WEST SUSSEX COUNTY COUNCIL CONSULTATION

TO:	Arun District Council FAO: David Easton
FROM:	Highways, WSCC
DATE:	16/05/2018
LOCATION:	Land West of, New Barn Lane, Bersted
SUBJECT:	BE/40/18/PL New access from New Barn Lane to Land West of New Barn Lane & relocation of 5 No. existing parking spaces.
DATE OF SITE VISIT:	N/A
RECOMMENDATION:	☐ Advice ☐ Objection ☐ Modification ☒ No Objection ☐ More Information ☐ Refusal
S106 CONTRIBUTION TOTAL:	N/A

Proposed Access to New Barn Lane

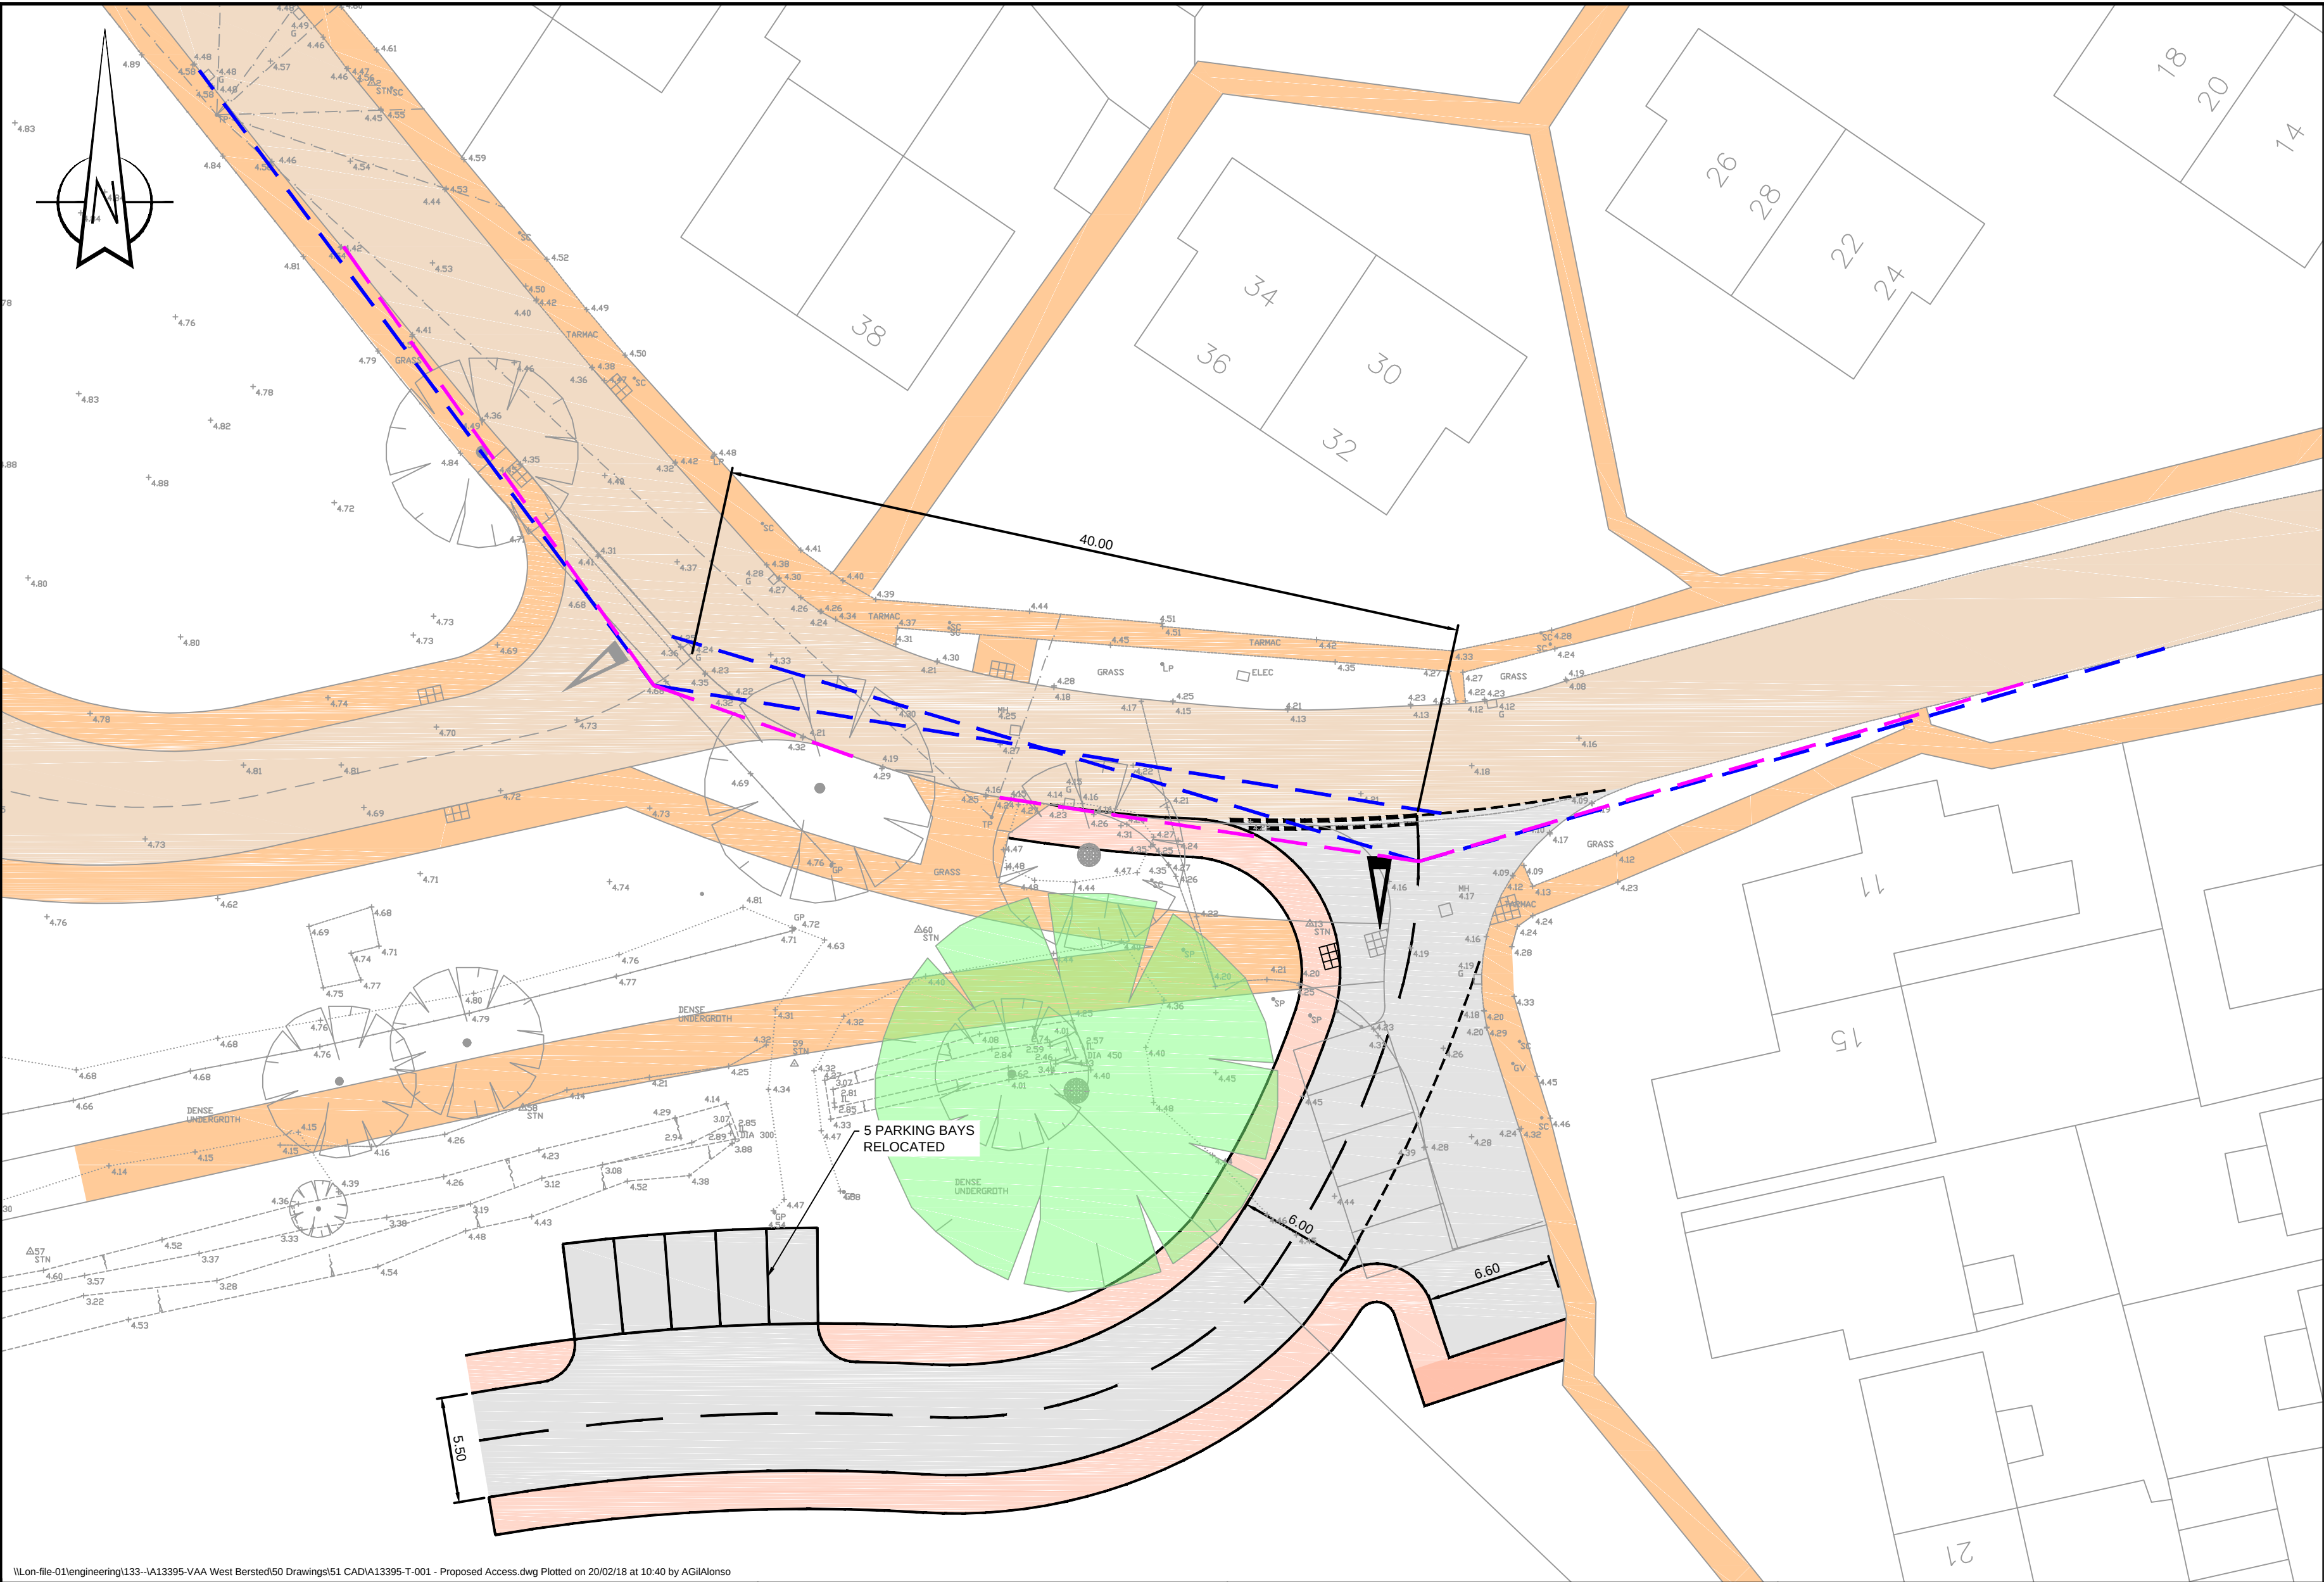
The proposed access arrangements as detailed on Pell Frischmann drawing A13395-T-001 detail that visibility splays in accordance with the recorded vehicle speeds for the road and the guidance contained within the Manual for Streets can be achieved. Given the guidance within the Chartered Institute of Highways & Transportation produced Manual for Streets 2 in relation to junction spacing the proposed proximity of this junction to the already consented one at the adjacent site is not considered to cause safety concerns that would warrant a refusal of planning permission.

The proposed arrangement does however provide adequate spacing of the recommended stopping sight distance based upon recorded 85th percentile vehicle speeds. The proposed access has also been subject to an independent Stage 1 Road Safety Audit. The provision of the 5 car parking spaces along the site access does not guarantee the

use of these spaces to existing residents, however given the level of on-street car parking availability in this area this is not considered to warrant a reason to refuse the application.

The Highway Authority have no objections to the proposed access arrangements but would look for a suitably worded condition to be included on any consent which requires the construction of the proposed access, as set out within the Pell Frischmann drawing entitled Proposed Access to New Barn Lane, drawing number A13395-T-001, to be implemented prior to the occupation of any of the residential units it serves (those associated with planning consent BE/77/16/OUT). The applicant should also be advised that they need to apply for the necessary post planning highway consent under Section 278 of the Highways Act 1980, the following informative should be included on any permission granted.
